Current Zoning: N-1 A (Neighborhood 1-A)  
Proposed Zoning: B-2(CD) LWPA (general business, conditional, Lake Wylie Protected Area)

Approximately 1.66 acres located on the south side of Mt Holly-Huntersville Rd between Bellhaven Blvd and Abbington Holly Dr.

The petition proposes to redevelop a site in the Coulwood neighborhood with a carwash including 4,500 square feet of gross floor area and accessory uses permitted in the B-2 district.

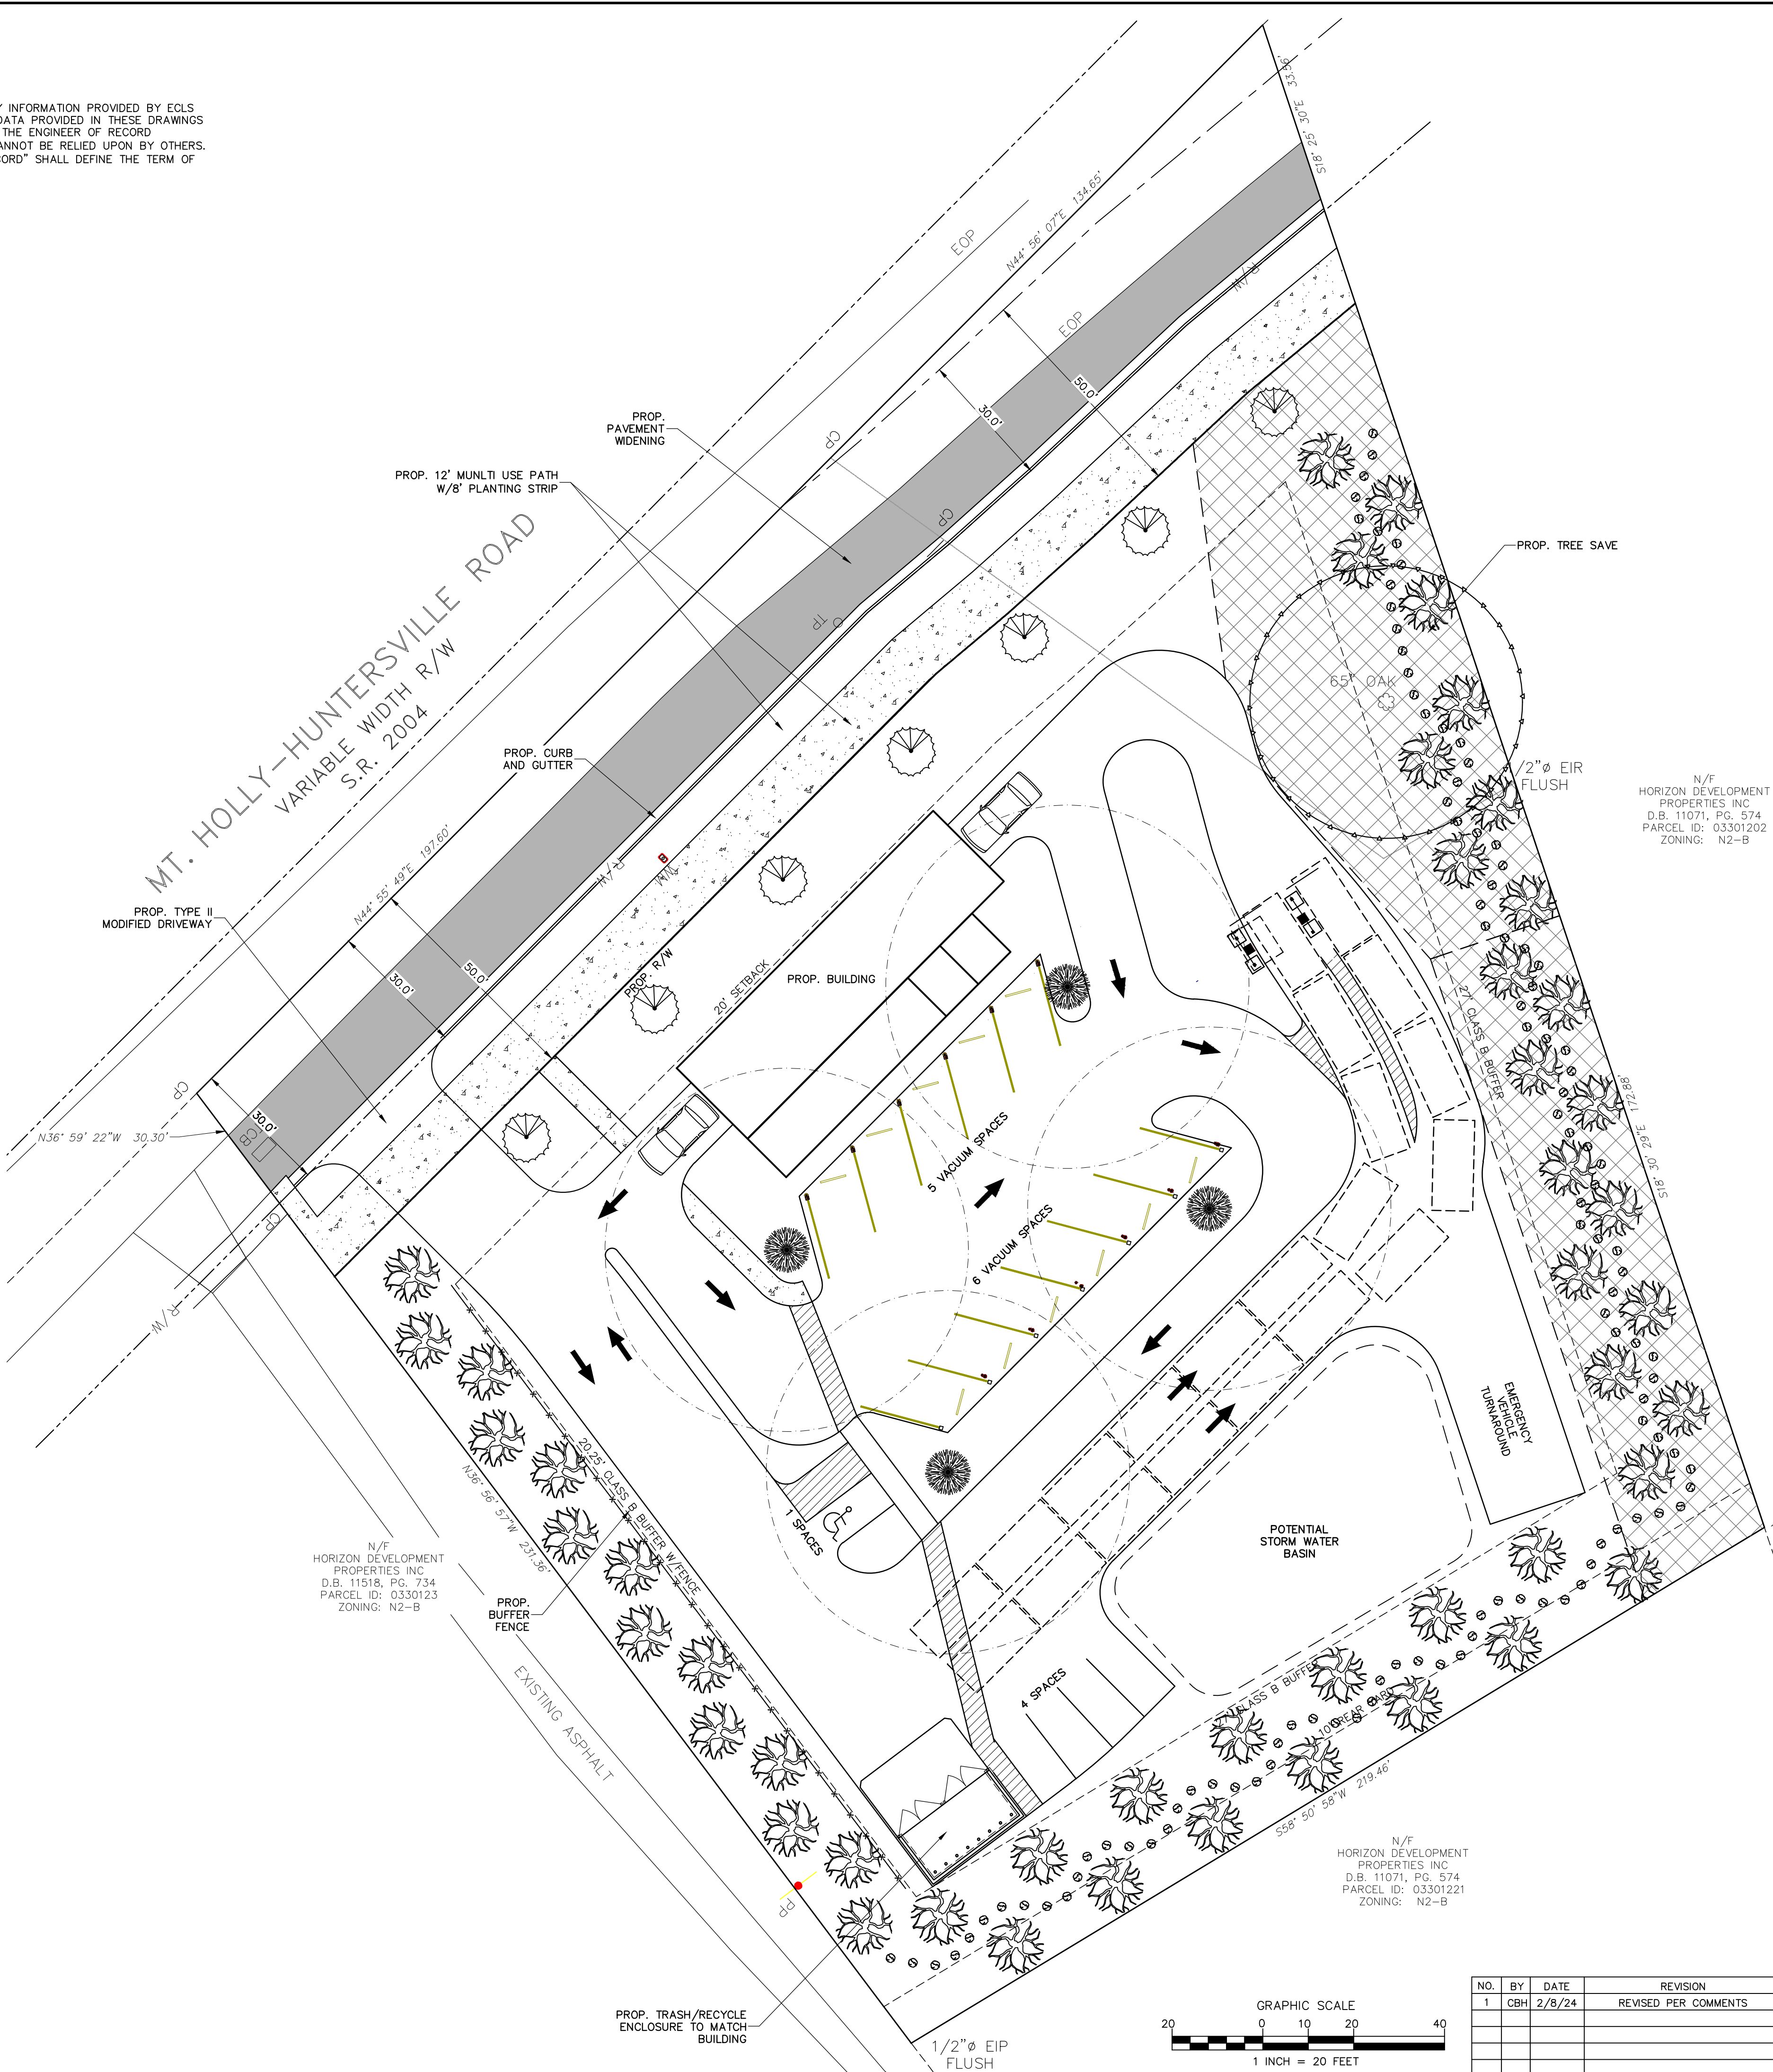
1. Remove note 5.b. stating that the 6' sidewalk and varied width planting strip along Mount Holly-Huntersville will remain. This conflicts with note 5.d. stating that an 8' planting strip and 12' multi-use path will be constructed.

2. Add conditional note stating that the petitioner will make a concerted effort to preserve the 65" oak tree on site.
